**Objection to Chimes redevelopment. 26 April 2025**  
**Application number: SSD-79316759**  
**Development Address: 45-53 Macleay Street, Potts Point**

**Elizabeth and Nick Murray**

6253-A DA-6062 / 1

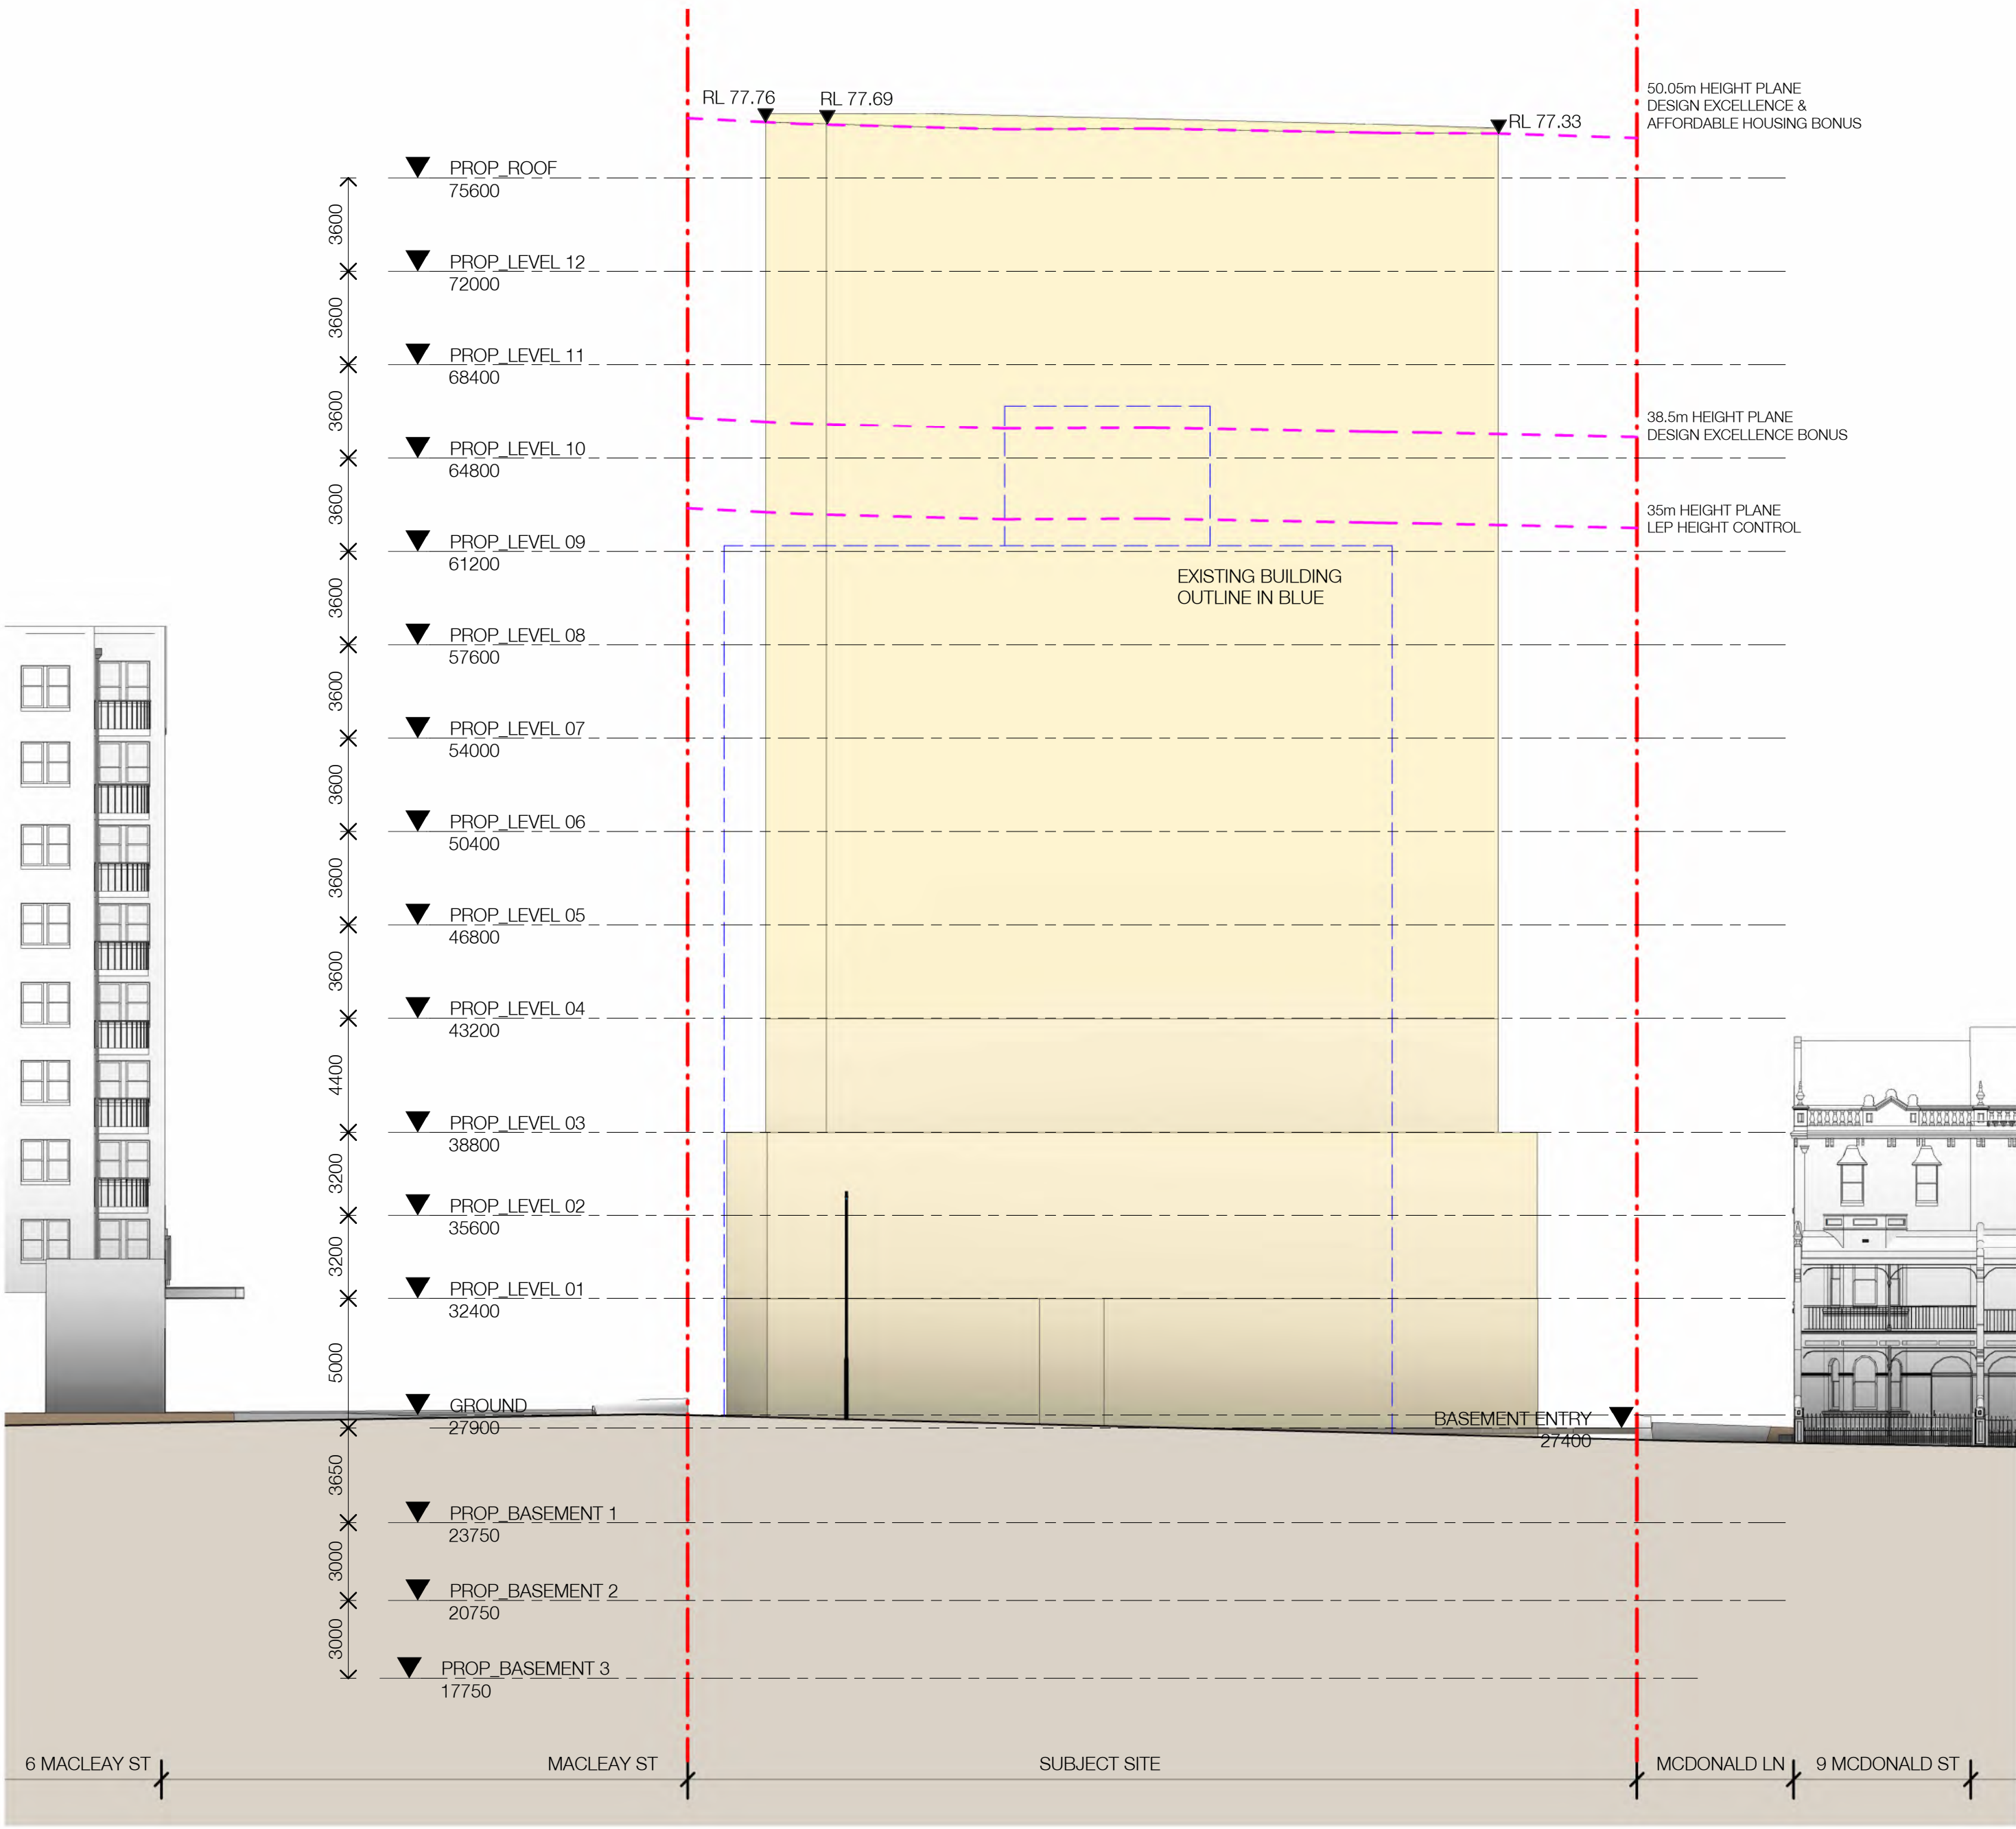
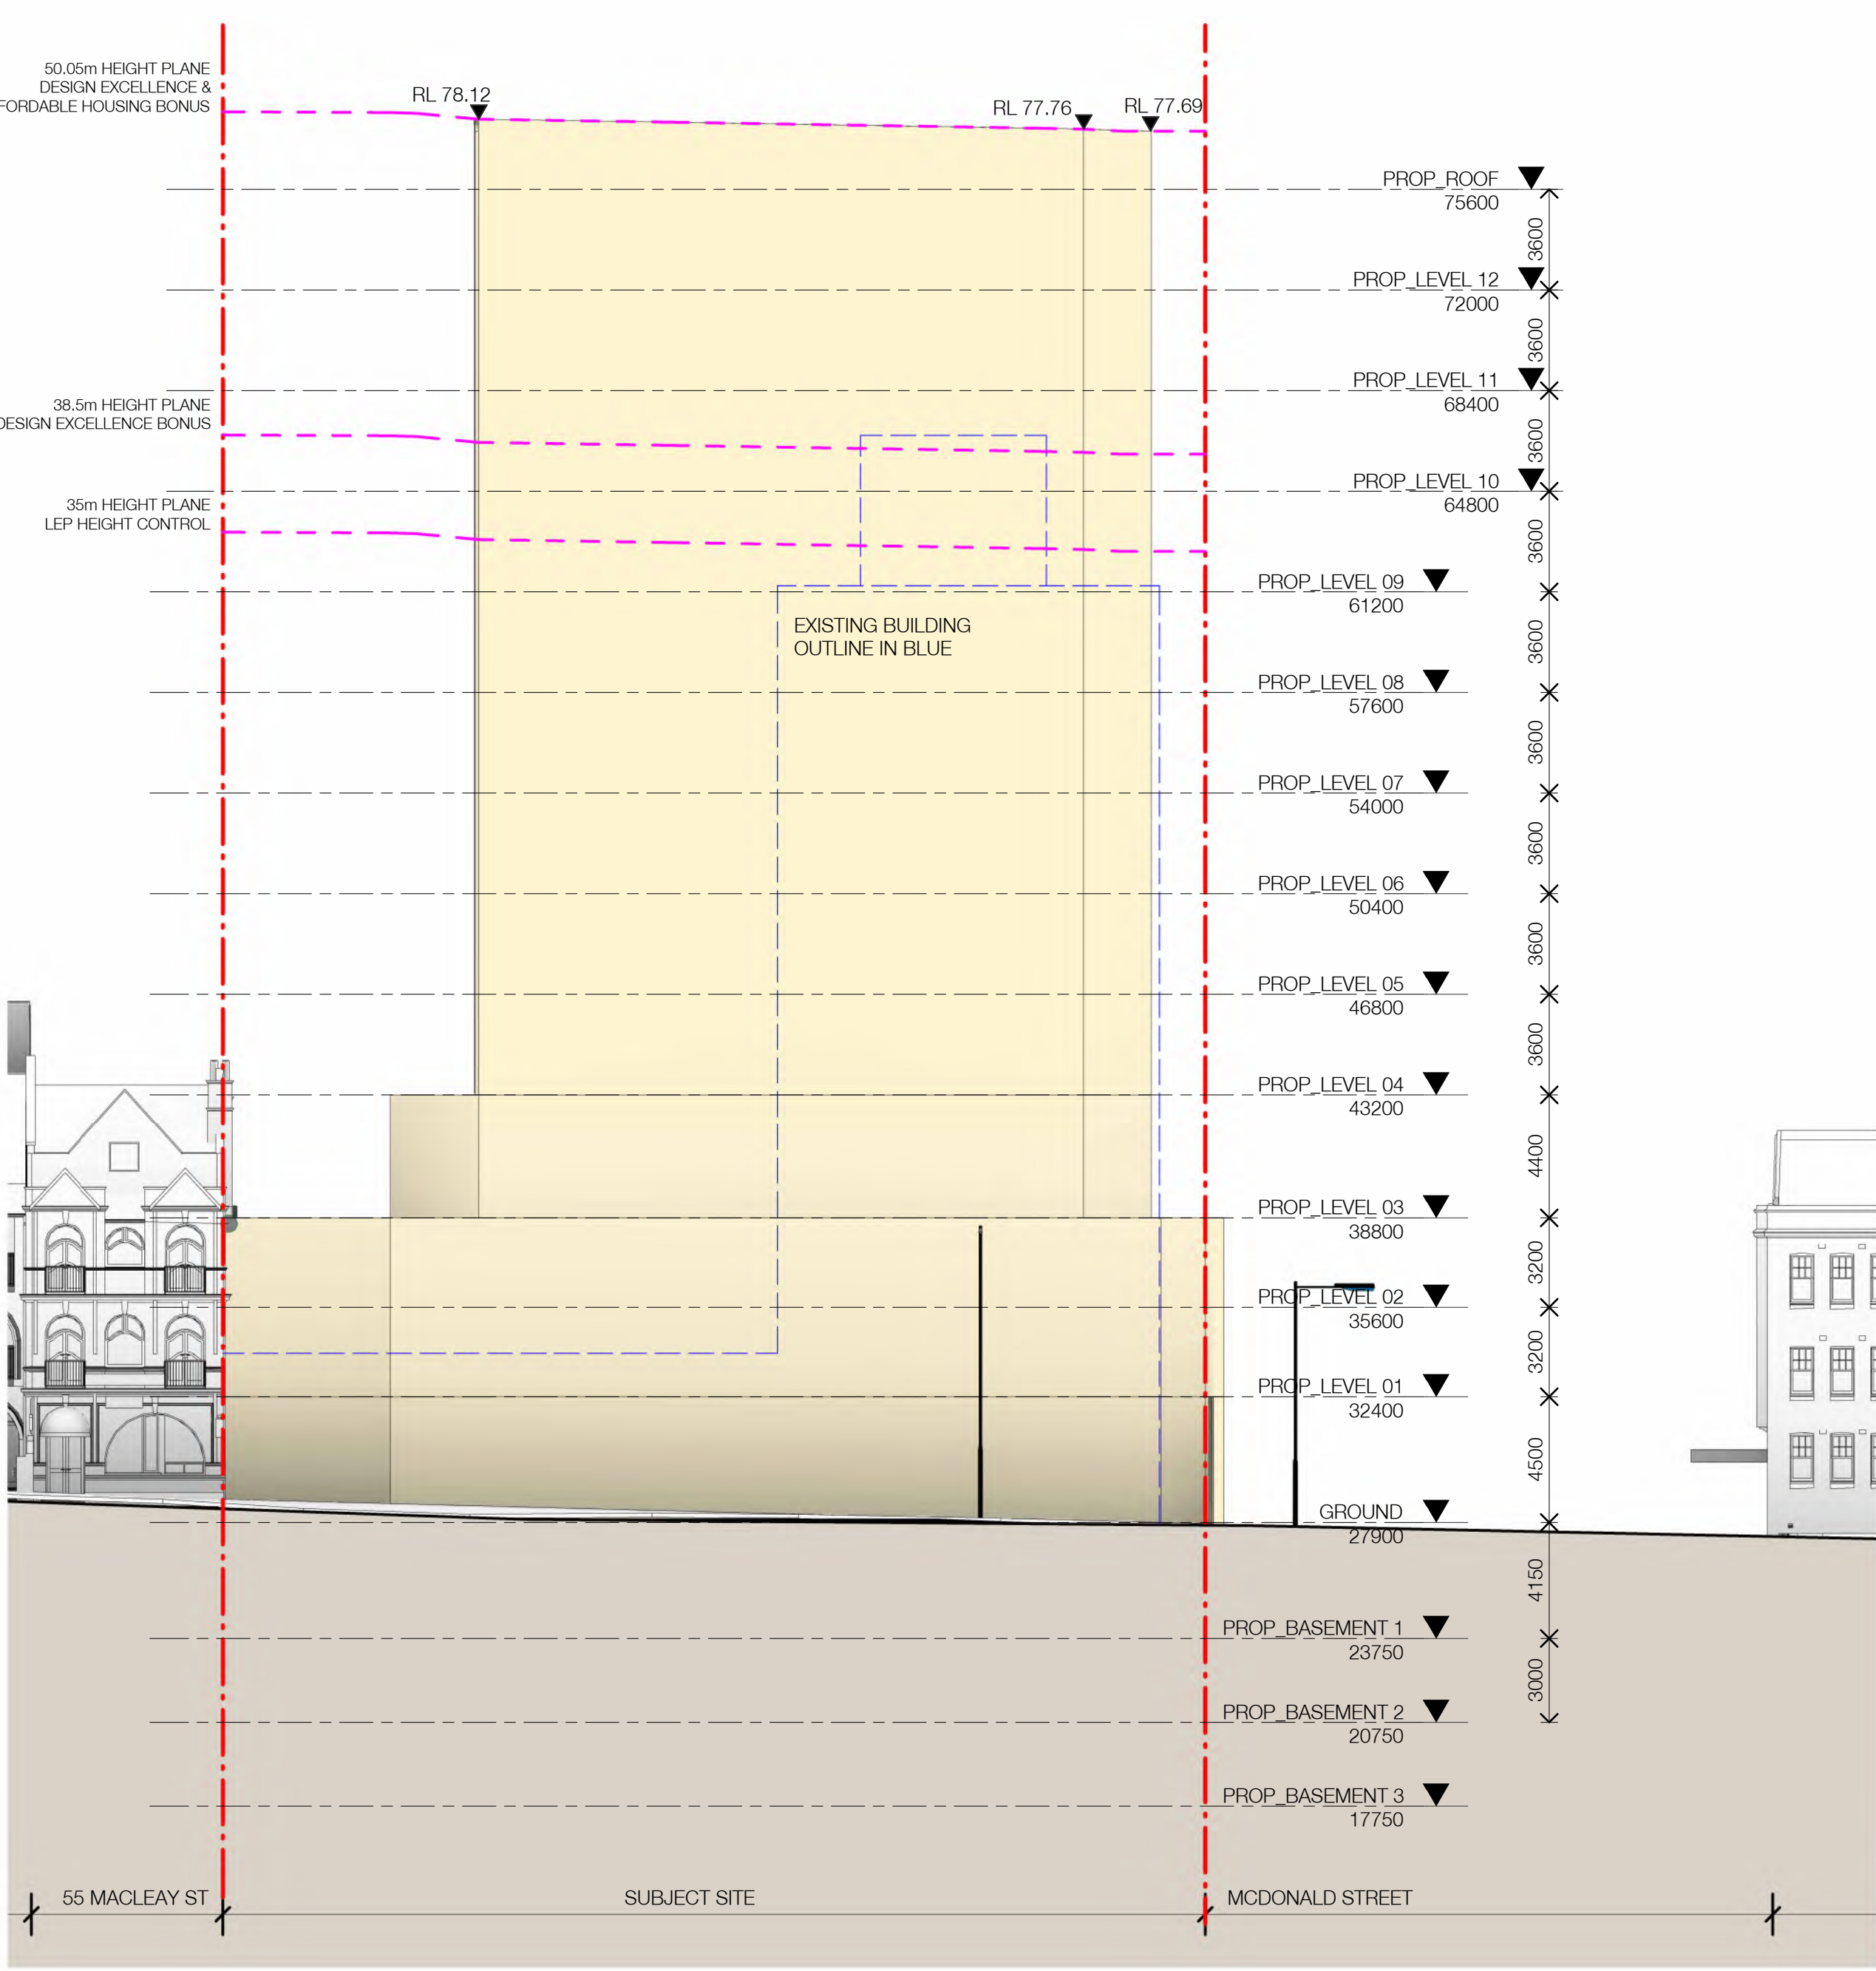
The additional 4 stories (or 15 metres extra height) being requested under the affordable housing rules, will make the building the highest for several blocks. The extra floors and floorspace add unacceptable bulk and overshadowing to an already very dense suburb. The attached elevation plans (sourced from document G – Concept Envelope Drawings) show the view of the development from the north and east more than double the apparent bulk of The Chimes.
